DOC21/803589-27

**EPA Advice on Environmental Impact Statement for proposed Snack Brands Manufacturing Facility, Orchard Hills (SSD-18204994)**

Thank you for the request for advice from Public Authority Consultation (PAE-28034040), requesting the review by the NSW Environment Protection Authority (EPA) of the Environmental Impact Statement (EIS) for the proposed Snack Brands Australia Industrial Food Manufacturing Facility (SSD-18204994) at 2 and 14 Distribution Drive, Orchard Hills.

Figure 6 Location of assessed emission points

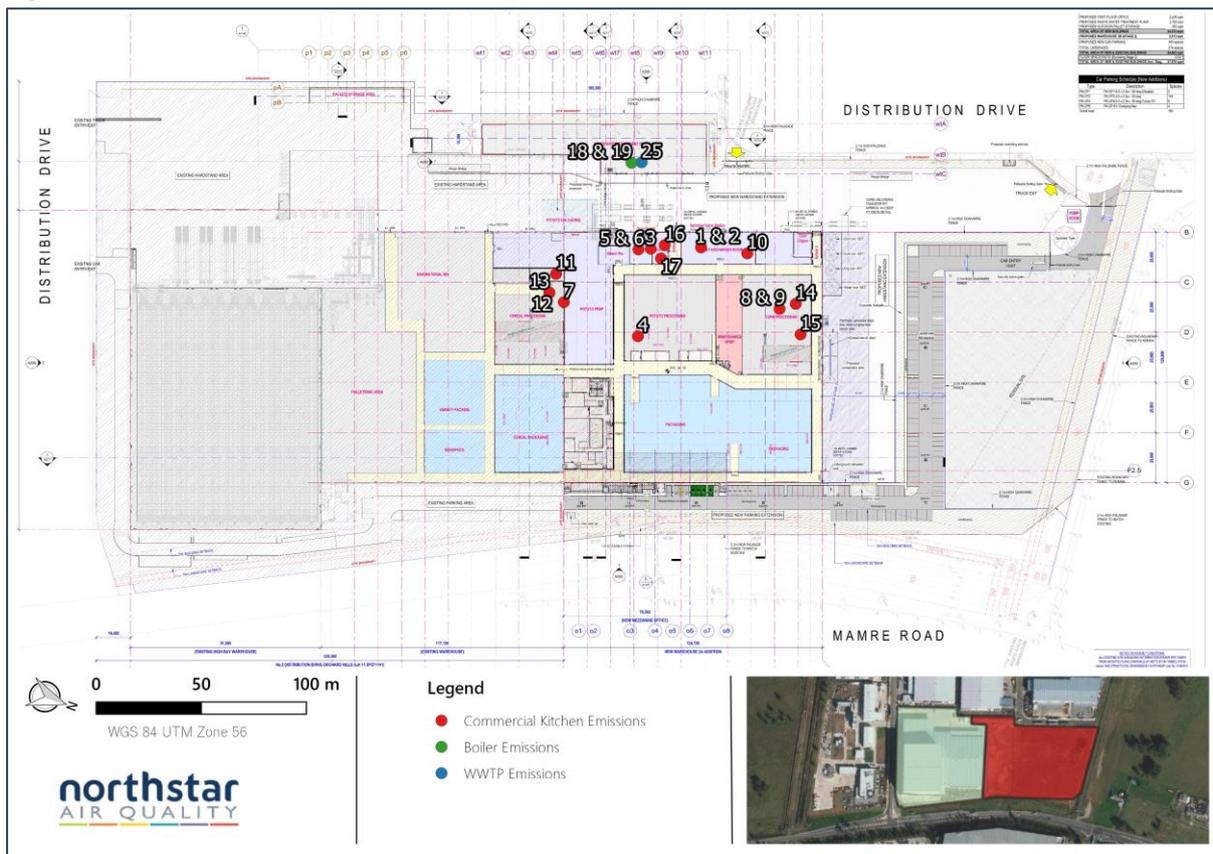
The AQIA indicates that there will be 17 commercial kitchen emission sources. It is understood that the emissions from 11 of these sources (identified as 1 – 11 as per Table D-1) will be controlled by a series of after burning waste heat boilers and subsequent heat exchangers.

However, the efficiency of these controls is not specified. It is also unclear if the monitoring results presented in the AQIA are representative of the implementation of these odour controls.

Further, it is unclear if the proponent has considered and evaluated engineering controls to reduce emissions from any of the other identified sources.

- Confirms whether the odour emission testing results are representative of the implementation of the proposed control equipment
- Provides additional information regarding the expected efficiency of the nominated odour control equipment
- Confirms whether engineering controls for all the identified odour sources have been evaluated and considered.
